**An Roinn Turasóireachta, Cultúir,
Ealaíon, Gaeltachta, Spóirt agus Meán**
Department of Tourism, Culture,
Arts, Gaeltacht, Sport and Media

Our Ref: **G Pre00220/2019**

02/02/2021

Re: Replacement of 7 manned level crossings at Limerick to Cork Line.

Figure 6: Aerial view of site, showing geophysical survey results and location of excavated test trenches

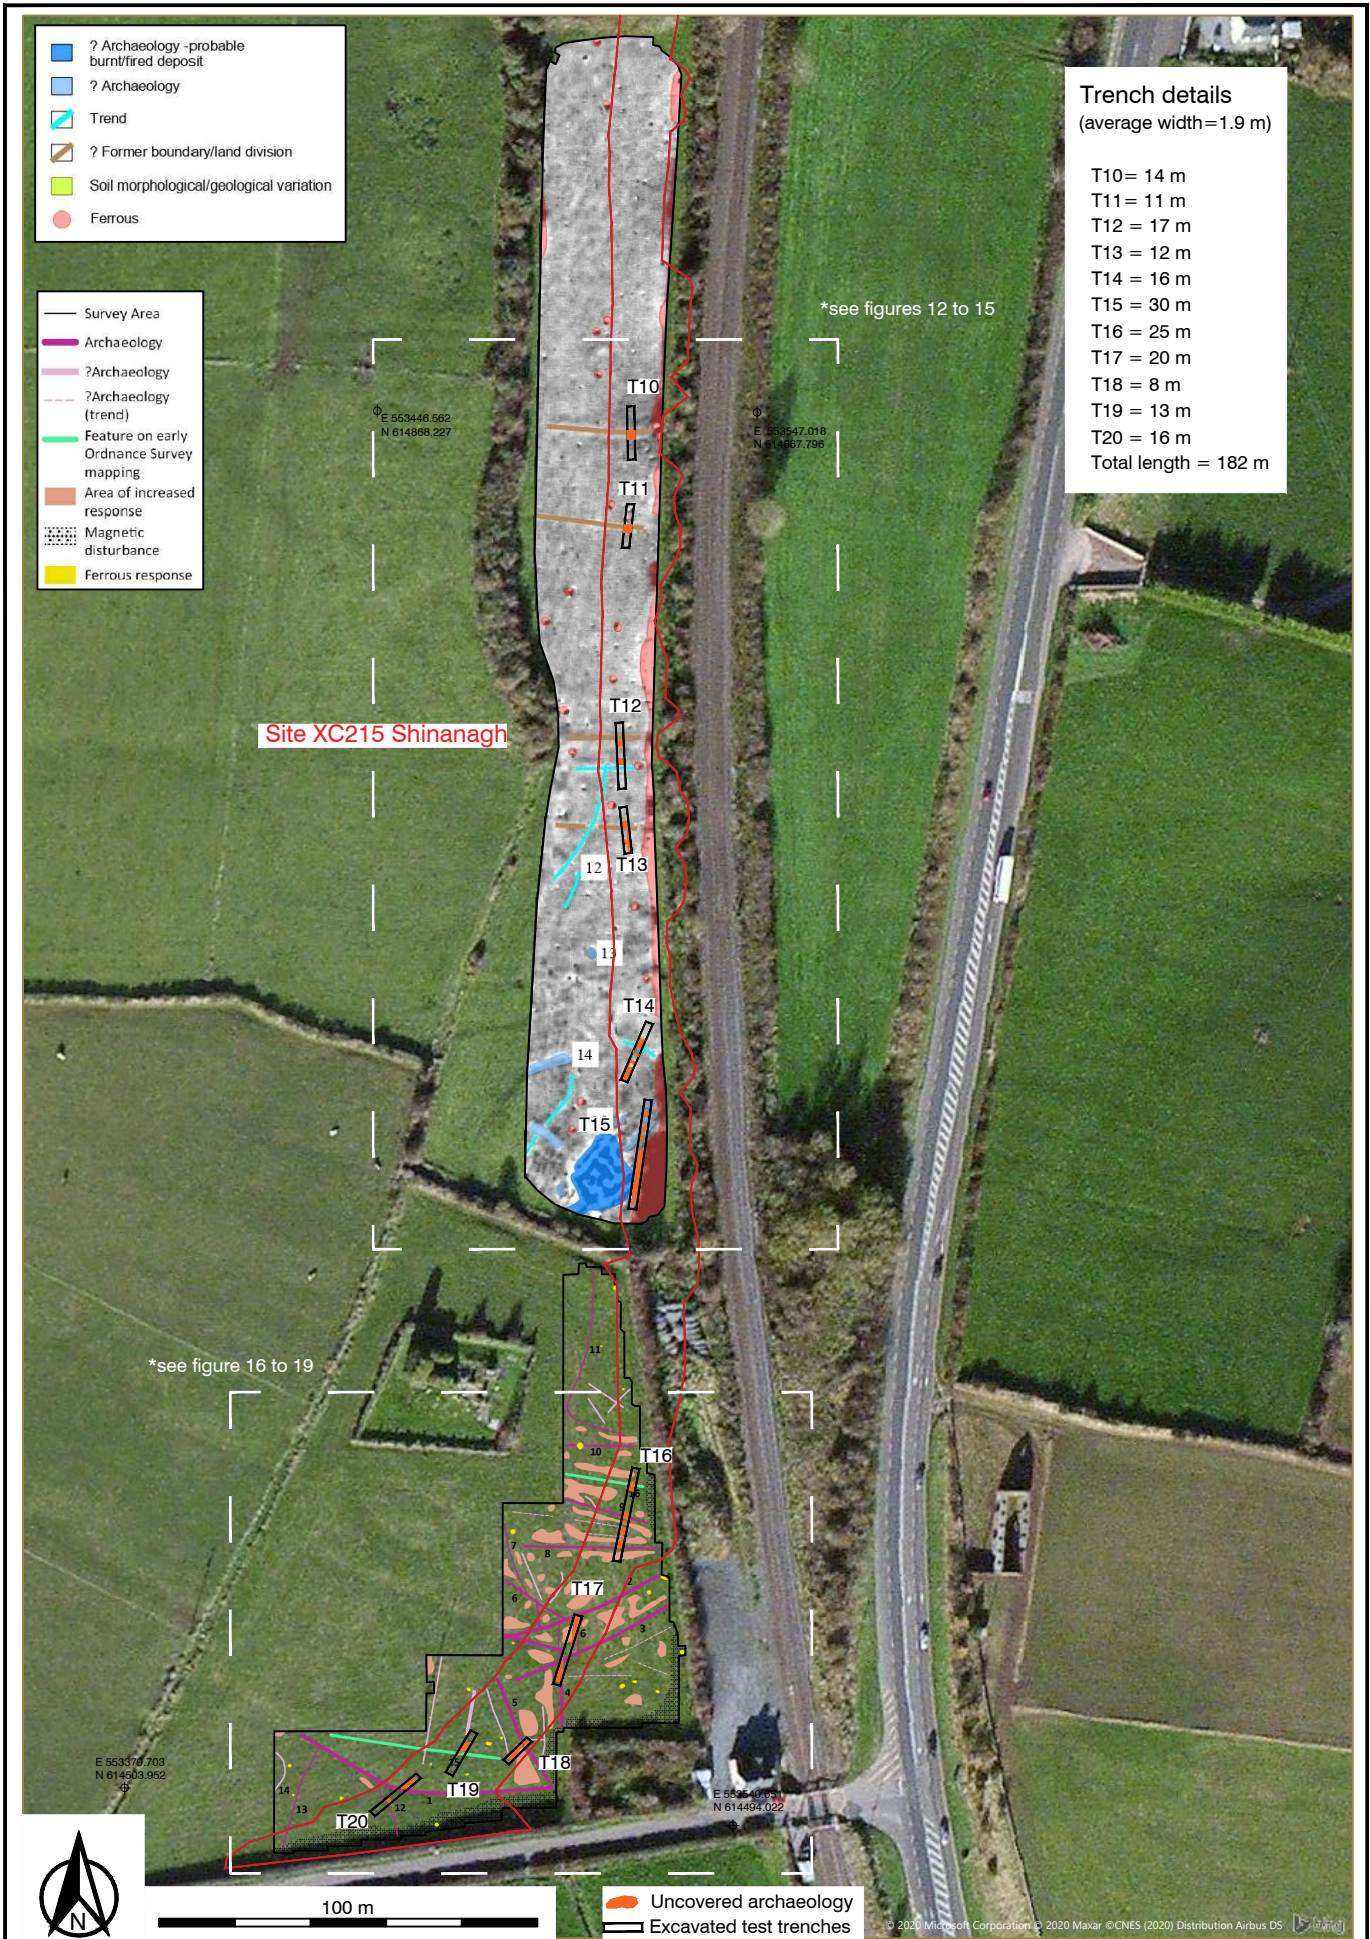
3. The results of archaeological testing at Shinanagh/Imphrick, Co. Cork (20E0639) has revealed two areas of concentrated archaeological activity – in the N/NE portion Field 1 (trenches 1, 2, 3, 4, 5 and 6) and in the S/SE portion of Field 2 (trenches 13, 14 and 15) adjacent to the scarped feature (which has now been established to be geological in nature). Given the extensive and possibly significant nature of archaeological features recorded in these areas it is recommended that open-area excavations take place according to best archaeological practice. These areas shall be excavated in full and a methodology for same shall be detailed in the Method Statement submitted with the licence application, in addition to a soil sampling strategy, post-excavation analyses and appropriate artefact recording and storage. The archaeologist shall consult with the National Museum of Ireland in this regard. A programme of more intensive archaeological testing shall be carried out along the rest of this route, between the two areas designated for excavation.

Figure 16: Aerial view of site XC215 Shinanagh Ballynageragh, showing interpretation of geophysical survey

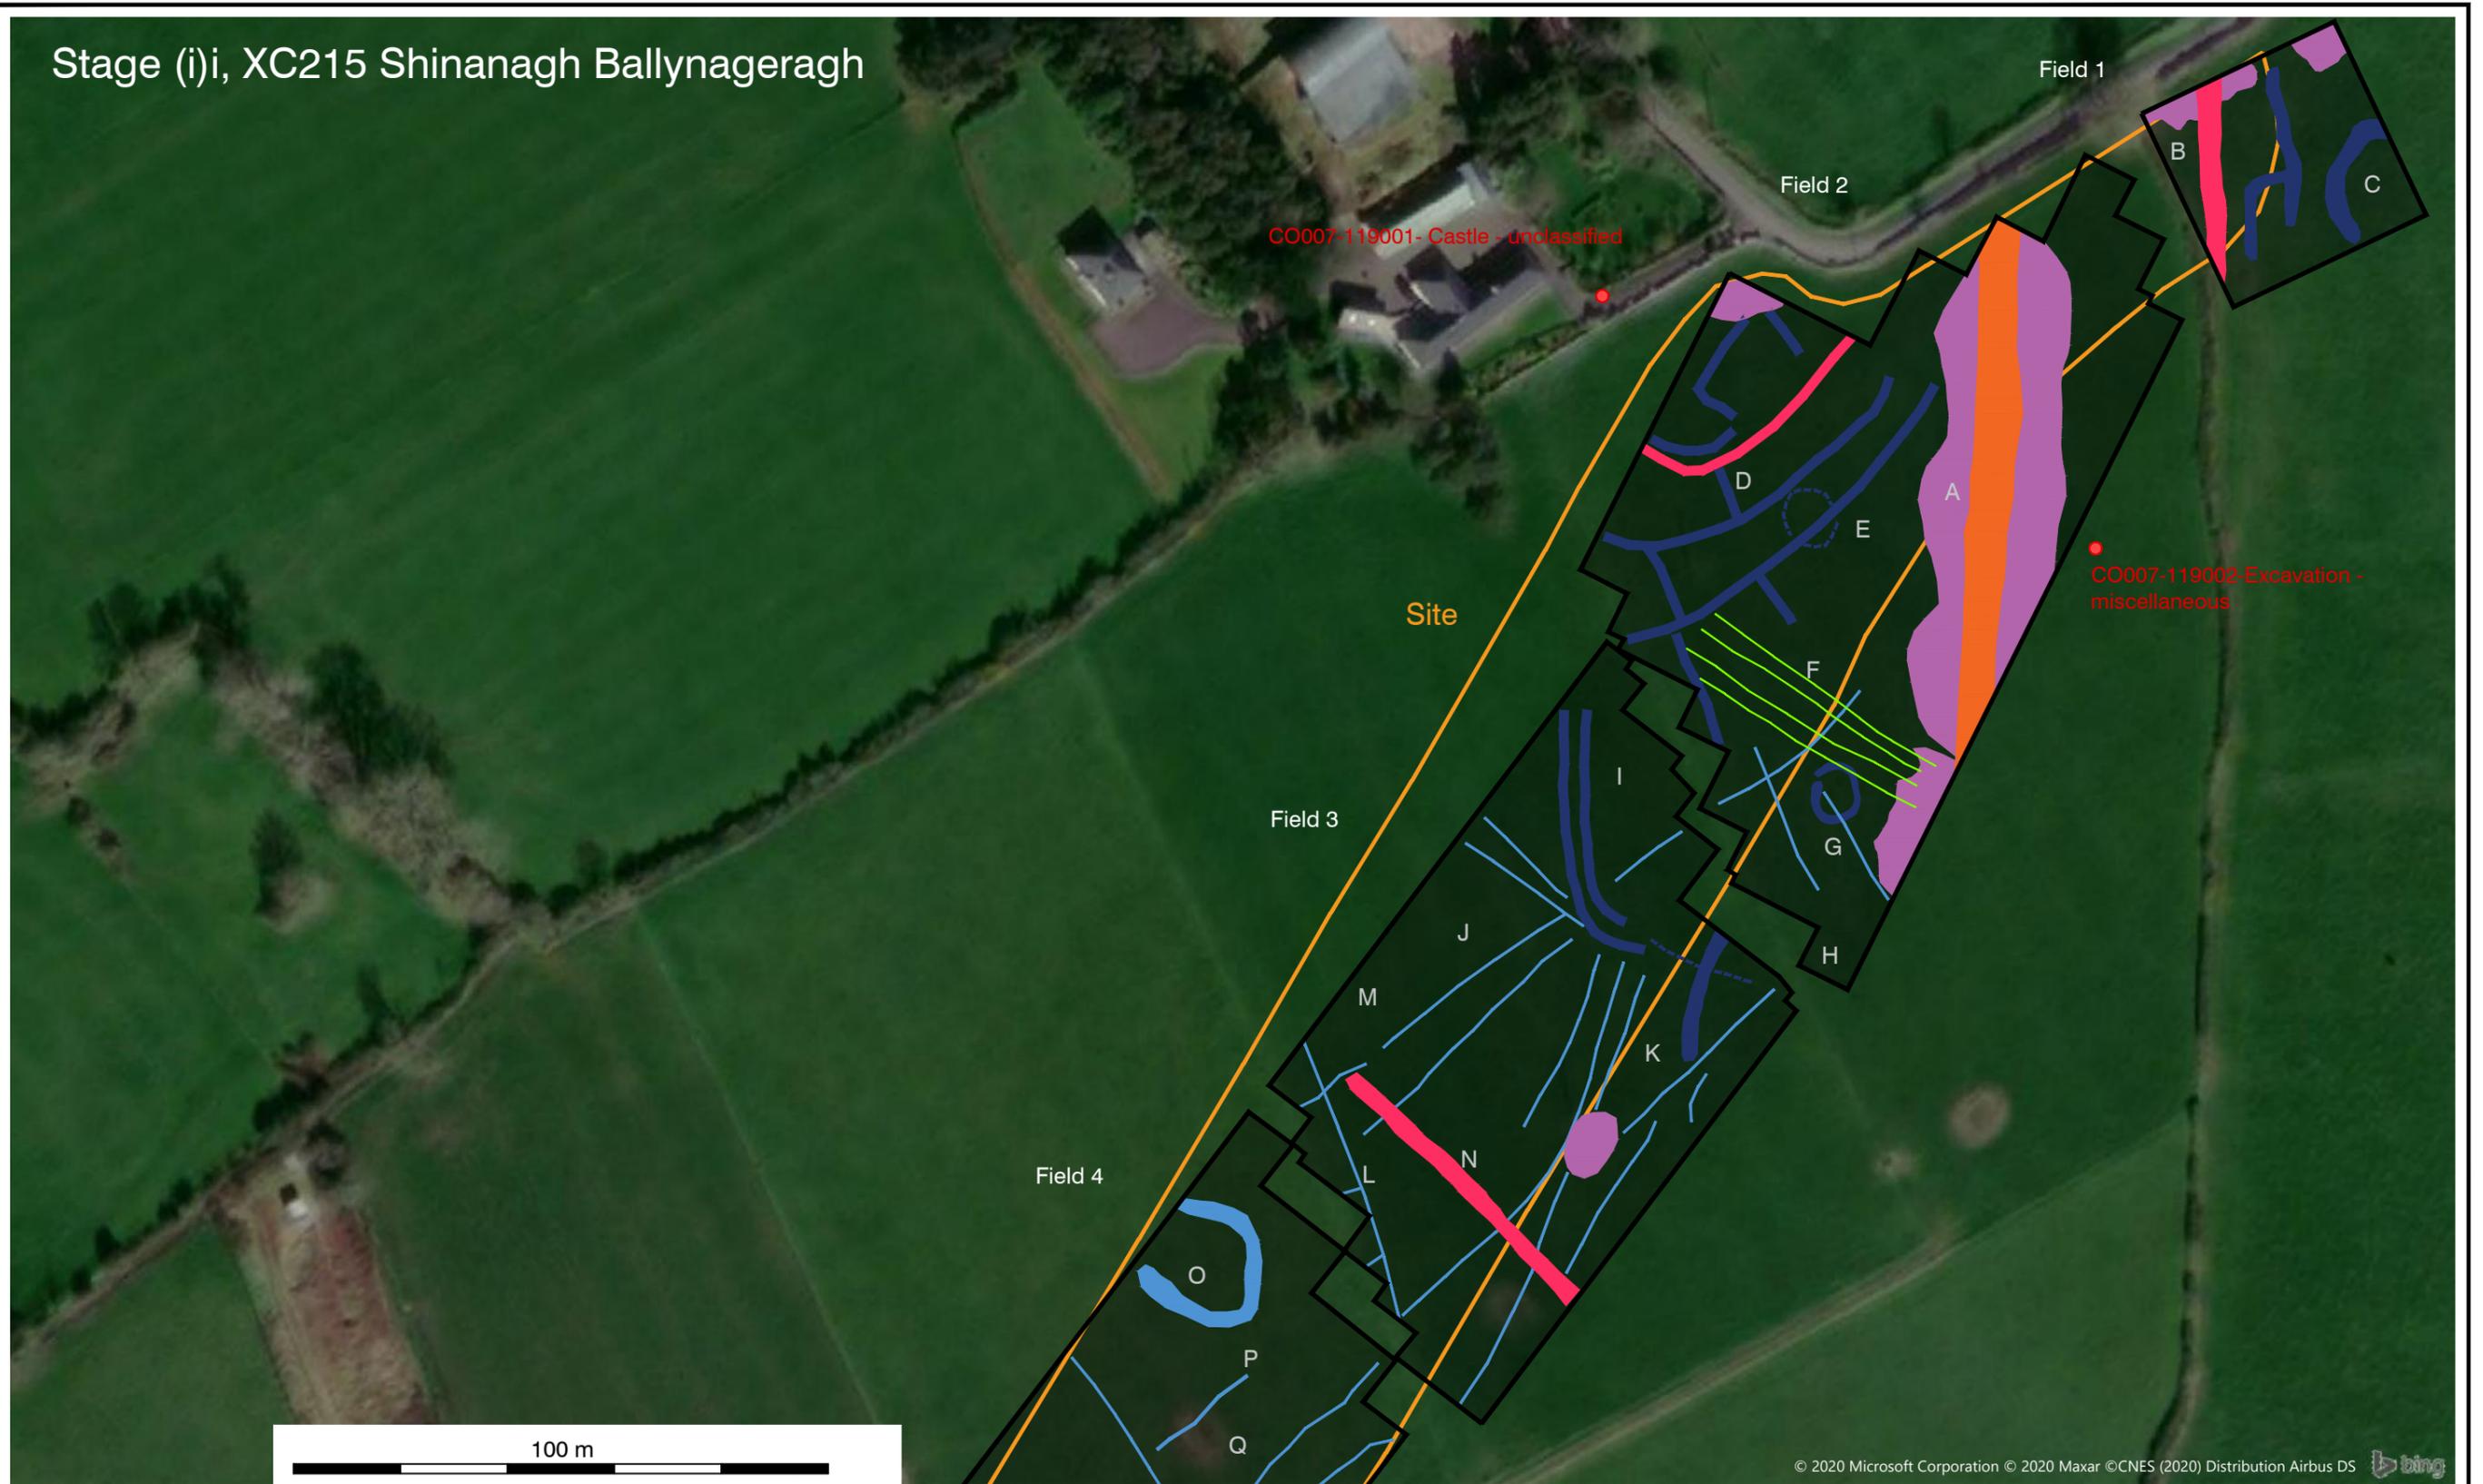
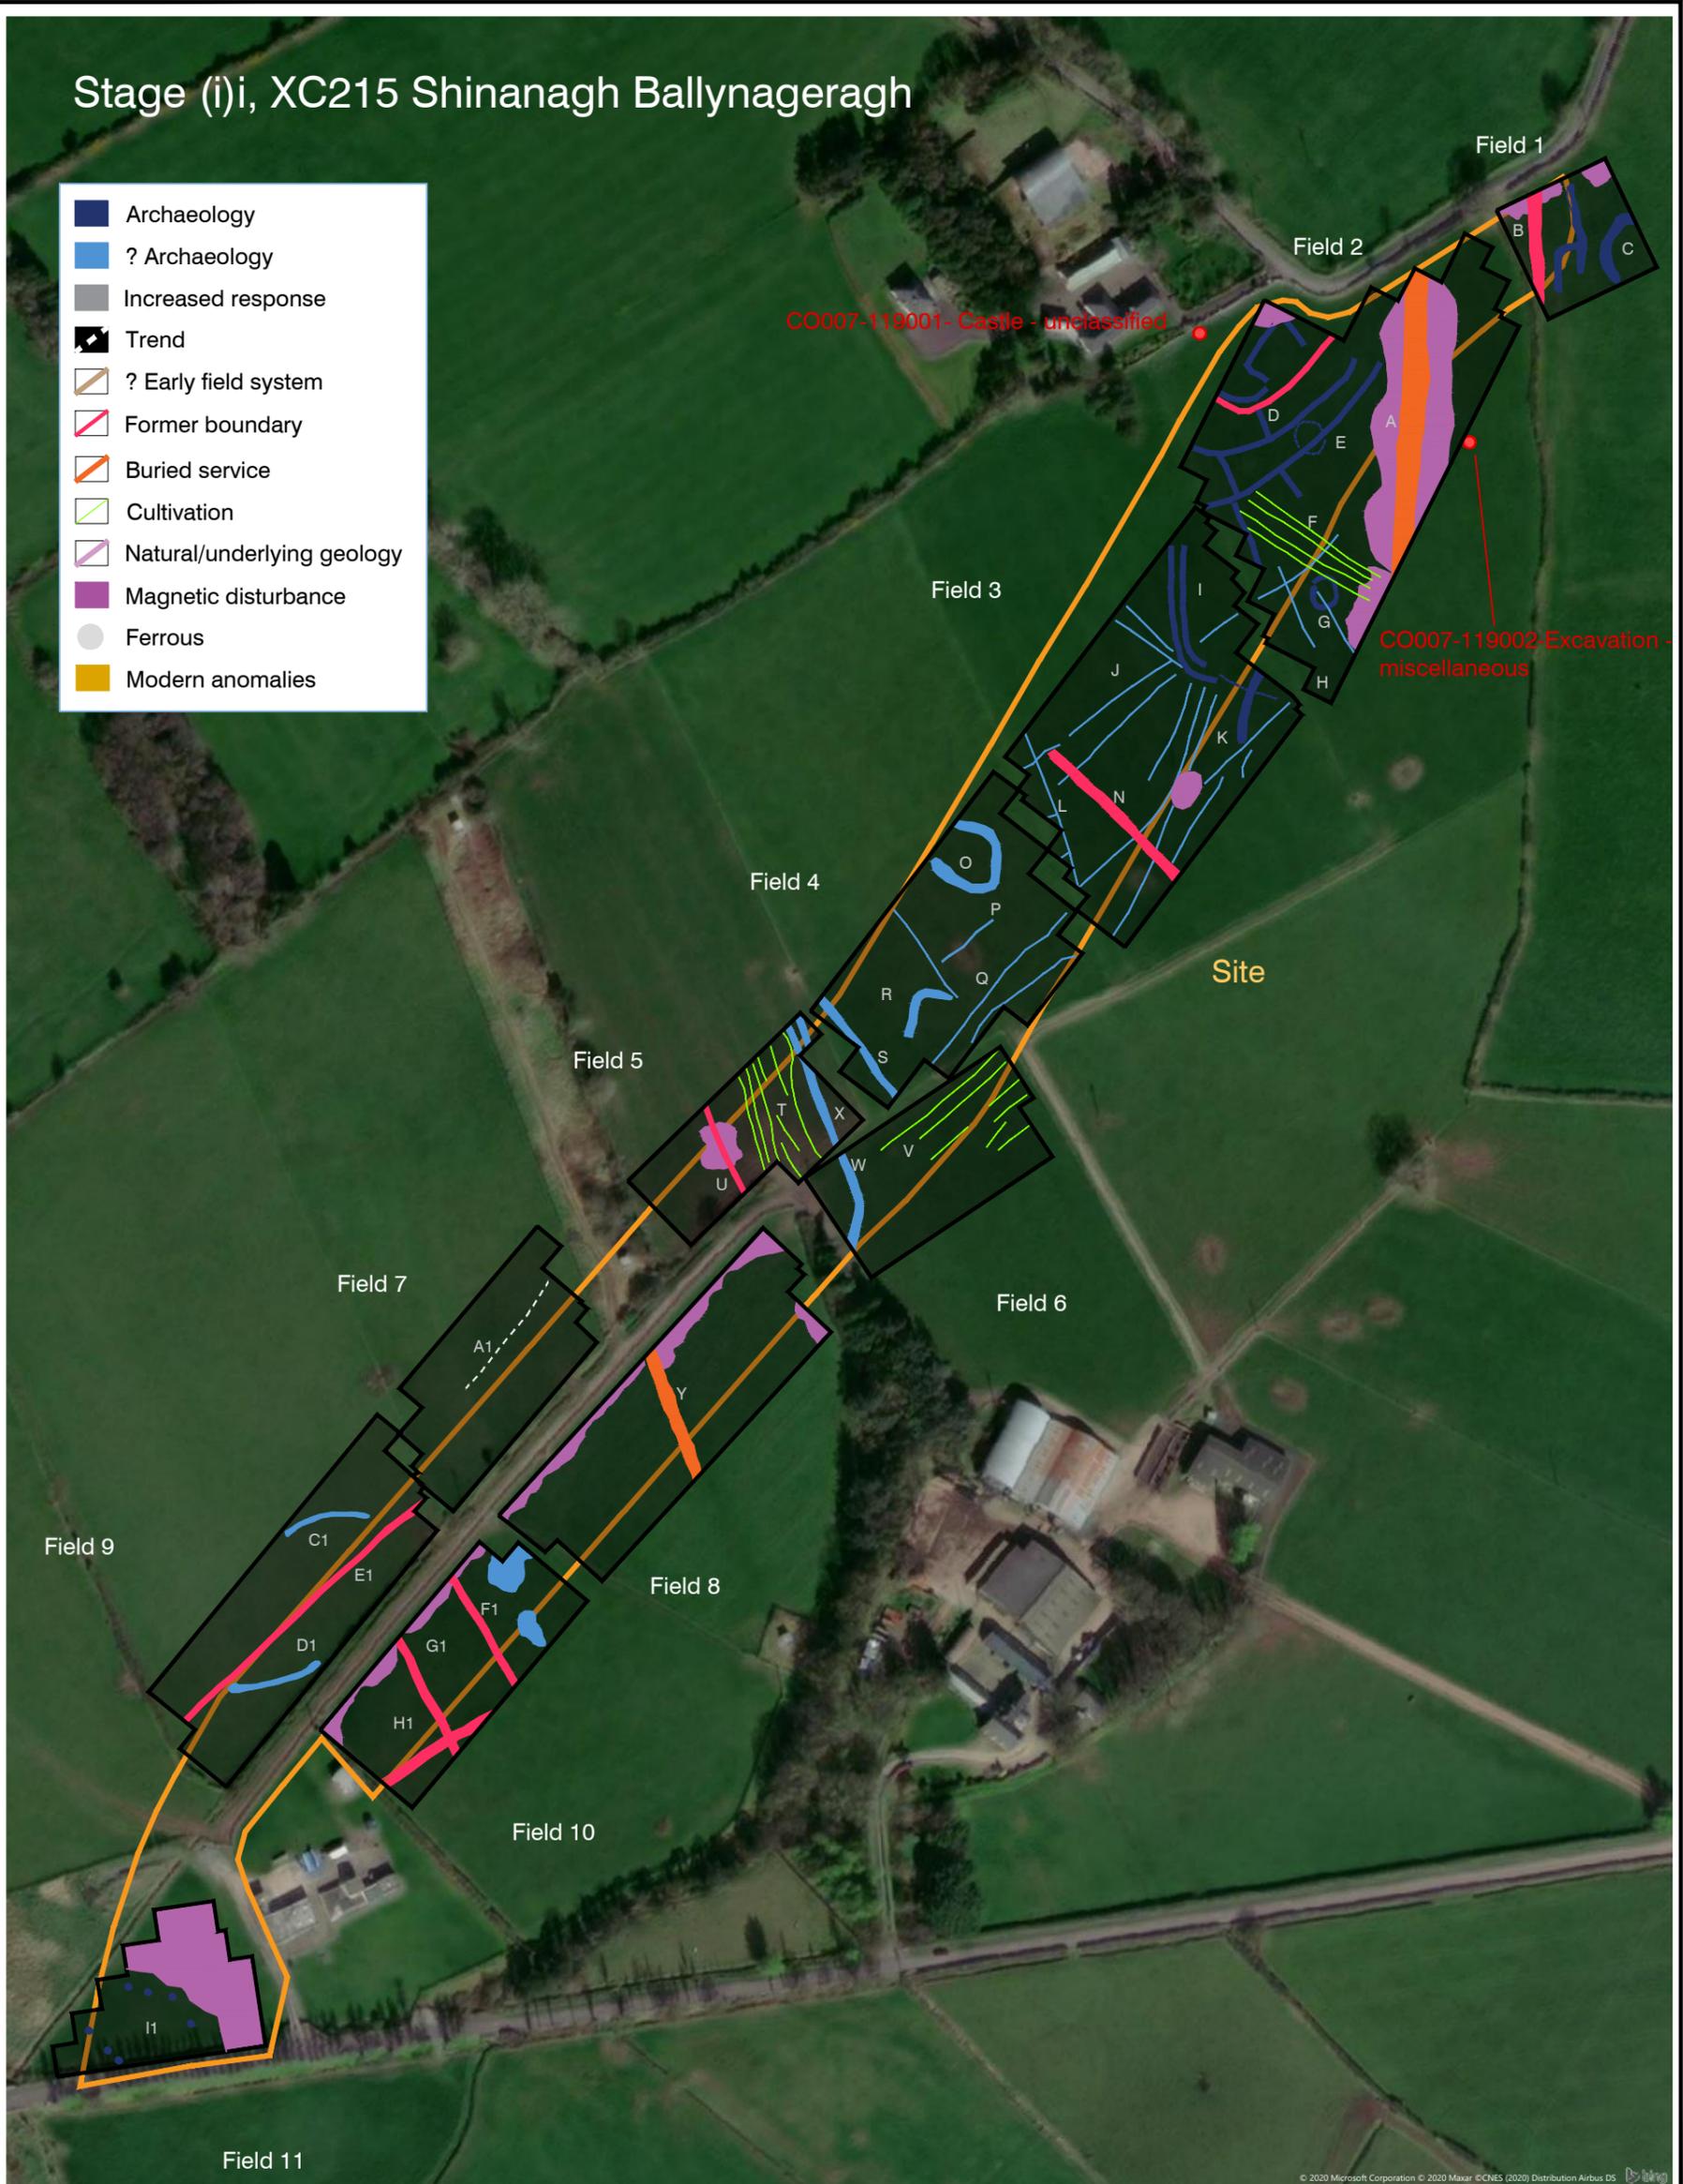
1. The Geophysical Survey carried out at Ballynageragh, Co. Cork (20R0239) has revealed extensive anomalies that are likely to be archaeological in nature. In this regard this site is not considered suitable for development, and should therefore be excluded from the project.
